ITEM 1.1 (b)

Issue/ Objection:
Visual Privacy

85 Harrington Street
The Rocks
GOLDEN AGE & HANNAS THE ROCKS

TITLE
RESPONSE TO DoPE
ITEM 1.1 (b)

TITLE
Elevations
Cumberland Place Elevations

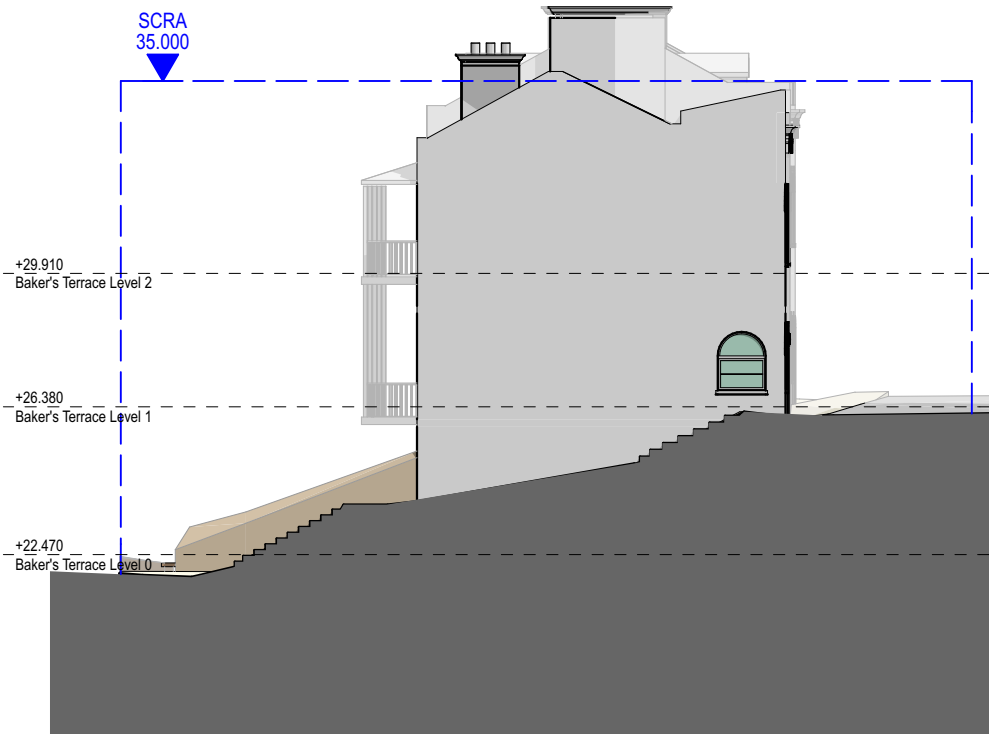
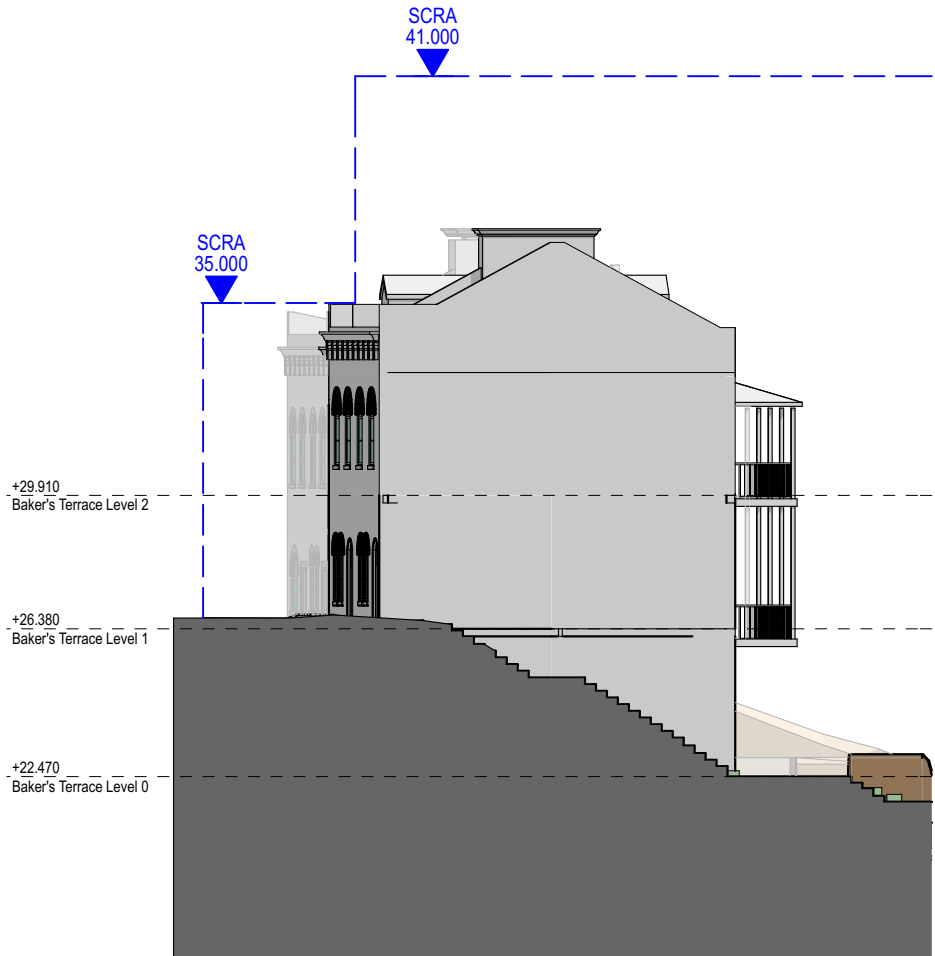
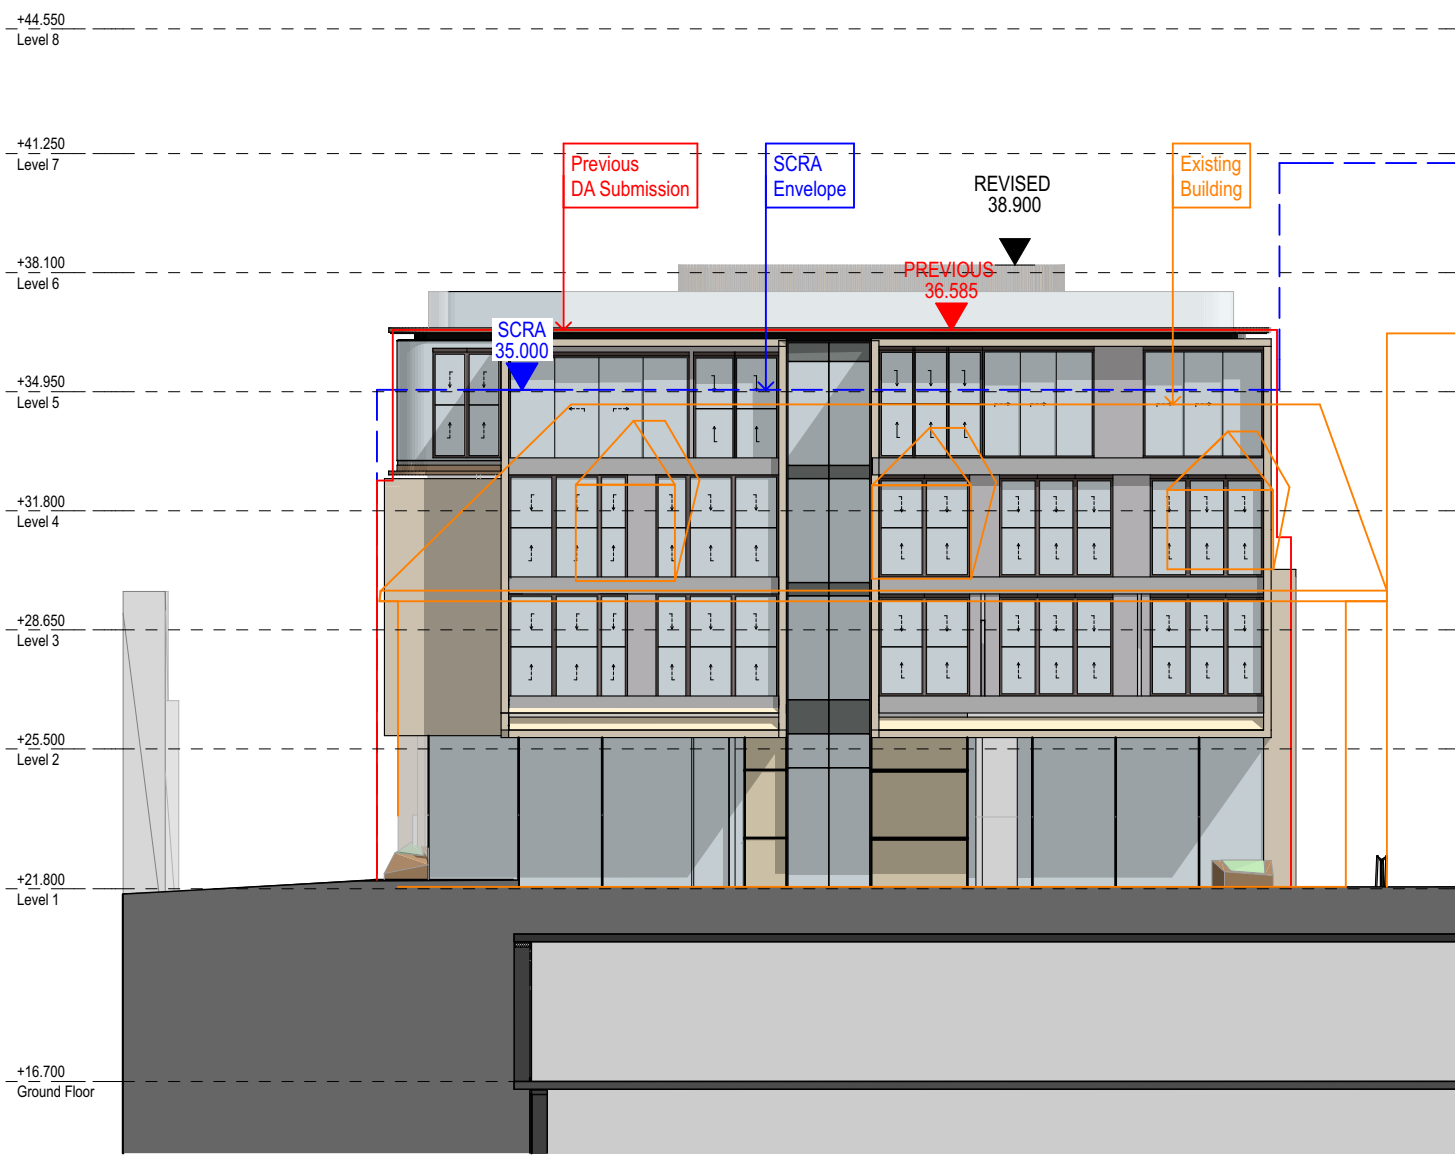
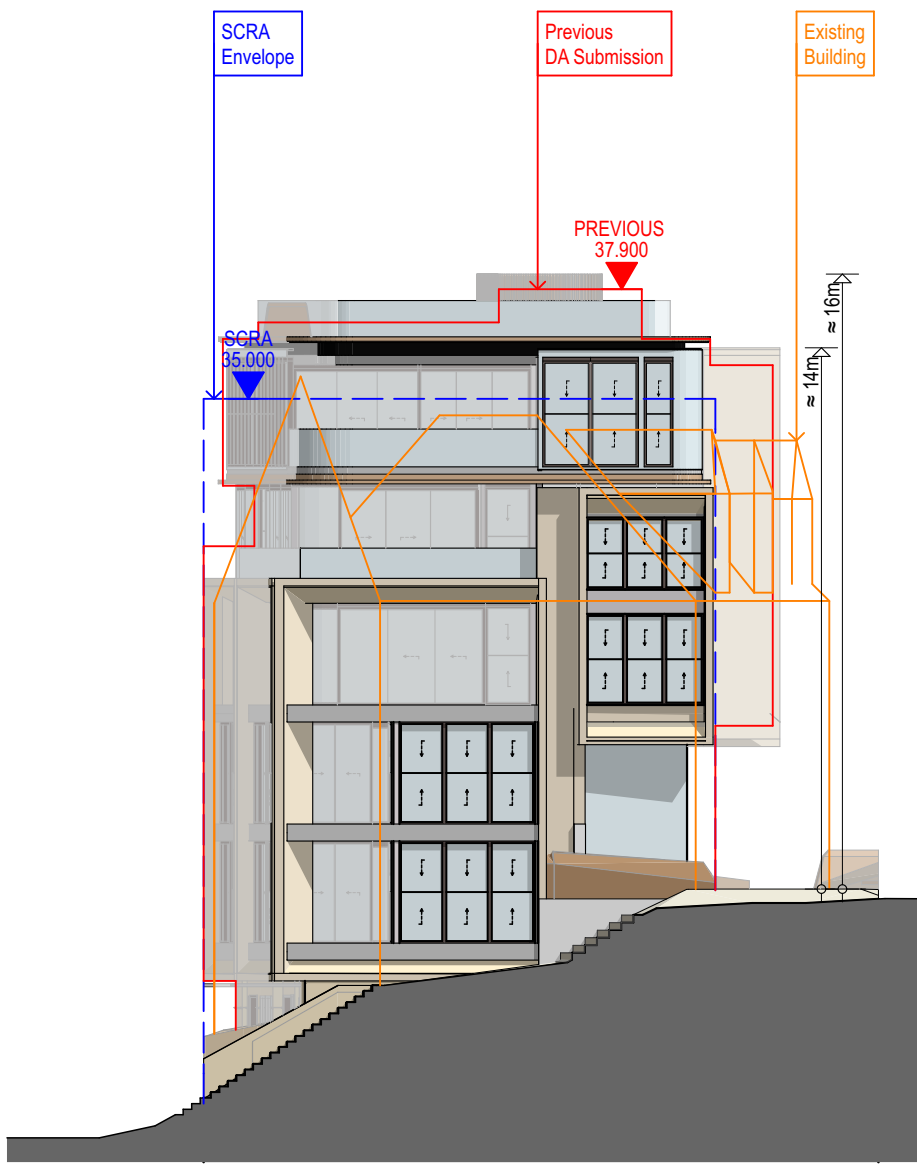
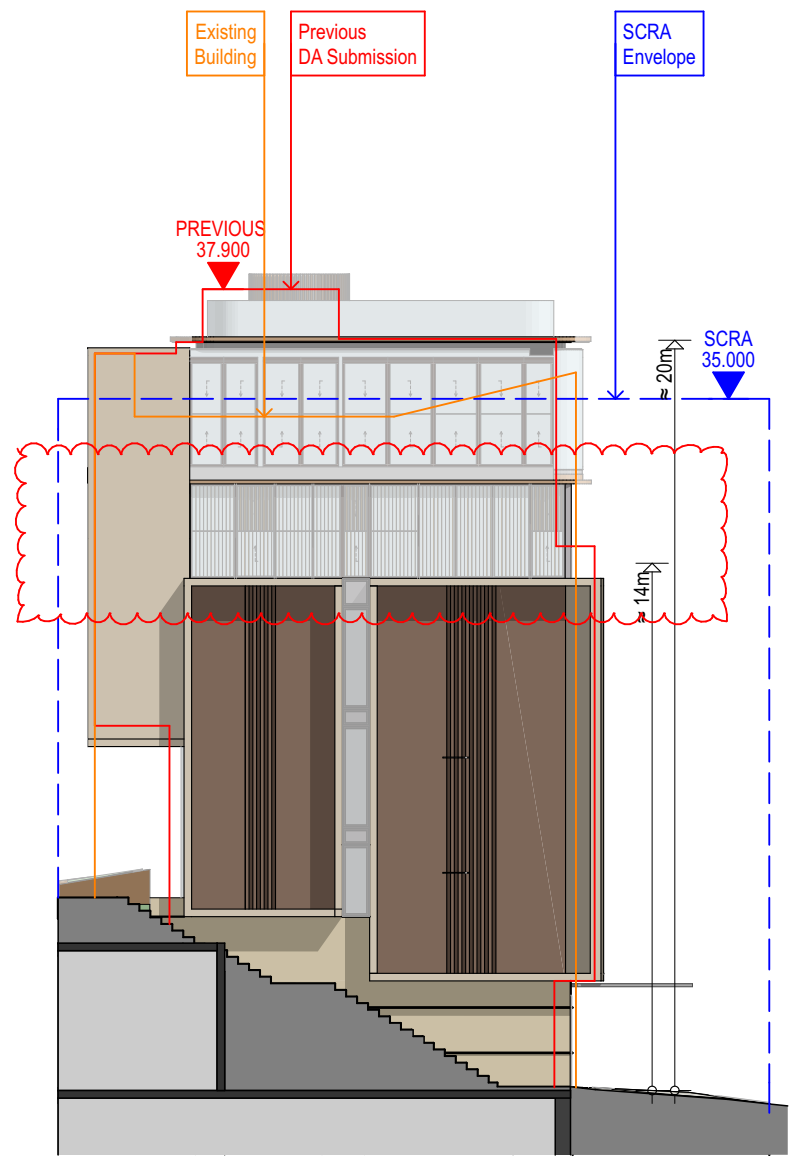
Description:
Description: Balconies serving units on Northern side of Building 2 have been reorientated towards Rendezvous Hotel. Provide a specific plan illustrating the varying setbacks between the two buildings, location of facing windows and balconies and proposed design measures to mitigate potential privacy impacts.

Response
Solid, operable shutters, or horizontal metallic blinds that are controlled by the occupants of the unit are employed to provide privacy towards the subject site. The windows of question within the rendezvous hotel are fixed, have dark glass and the rooms are itinerantly occupied. Any potential privacy issues have been mitigated through a considered design response. **Complies? Yes**
